City of Portland, Maine – Building or Use Permit Application 389 Congress Street, 04101, Tel: (207) 874-8703, FAX: 874-8716

March 1, 1999

RE: 215 Hicks Street - Duplex (CBL 296-B-014)

DUPLEX @ 215-221 HICK ST
 RALPH & PETER DESARNO
 WALL, ROOF & STAIR
 TYPICAL

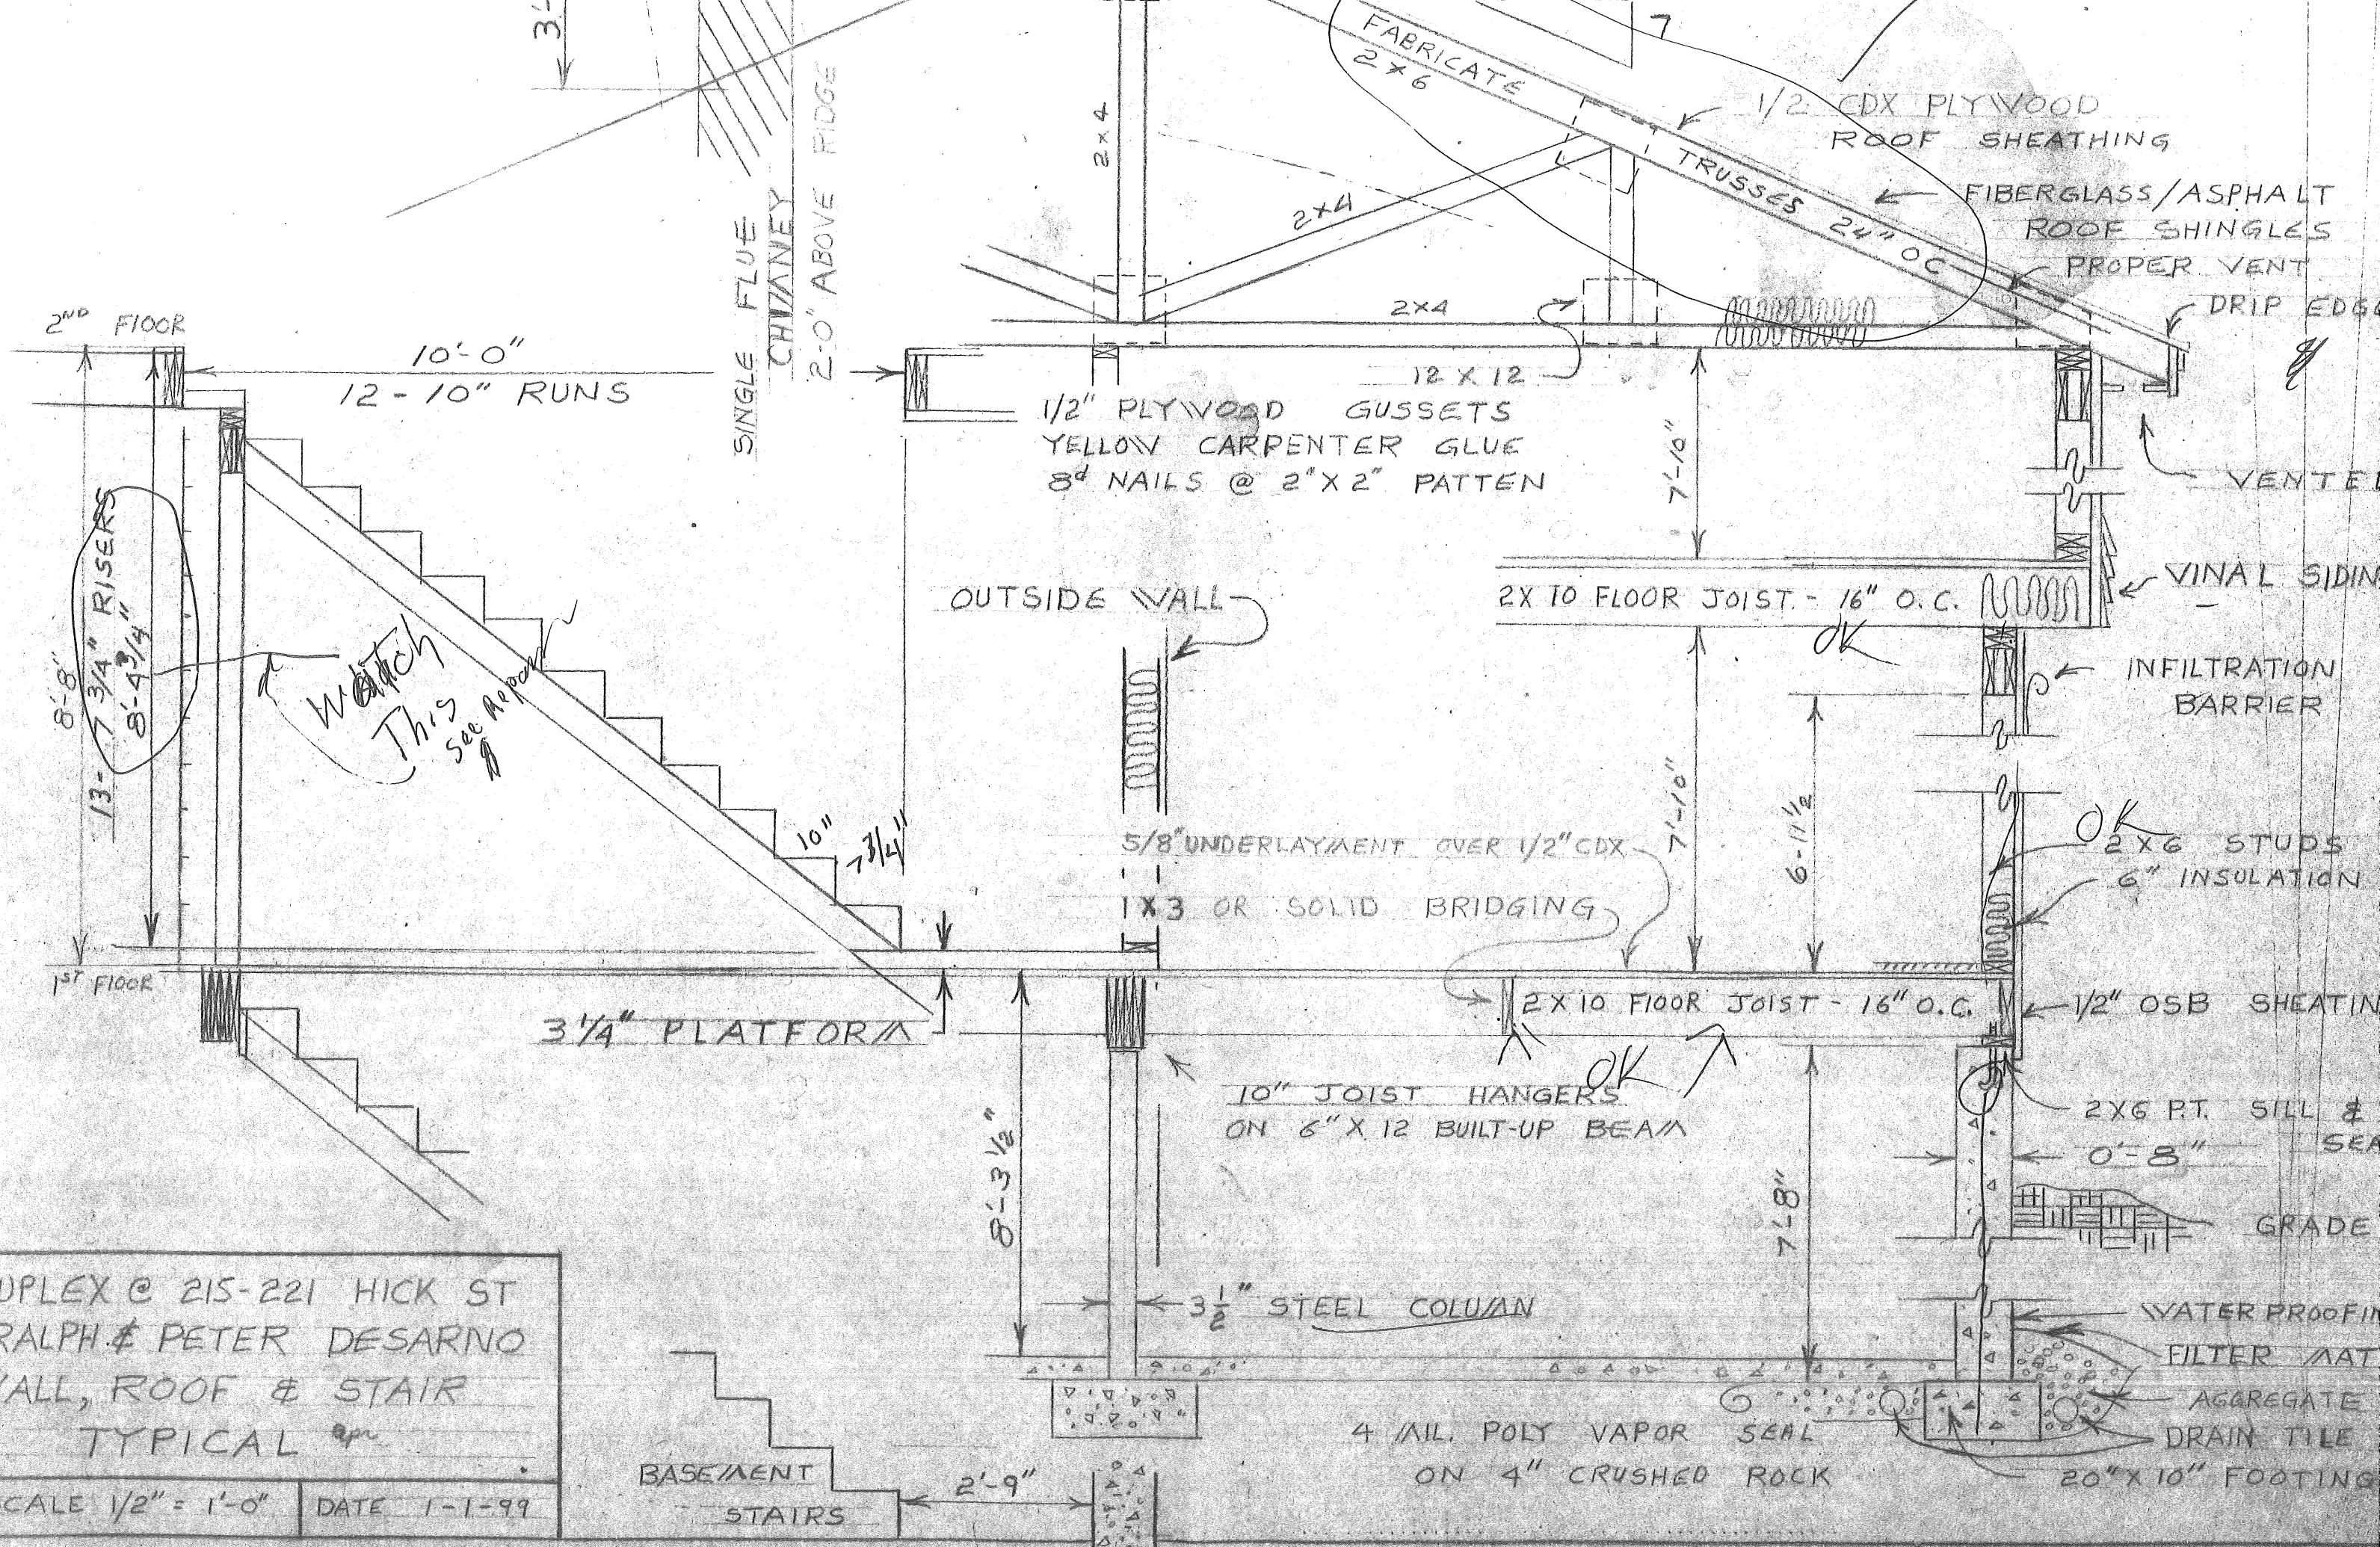
1. The estimated cost of the construction of this proposed building is revised to reflect a more realistic construction cost. You can get this by using the scenario that I was building the structure for you. - (materials and cost of labor)
2. The application plans shows fabricated truss (field built). Under sections (802.10 of the one and two family code) and under BOCA National Building Code/1996 Sections 2305.14, 2305.15, require that trusses to be designed in accordance with approved engineering practice. If you do not use manufactured trusses, you must have a complete detail of the trusses, designed and sealed by a structural engineer.
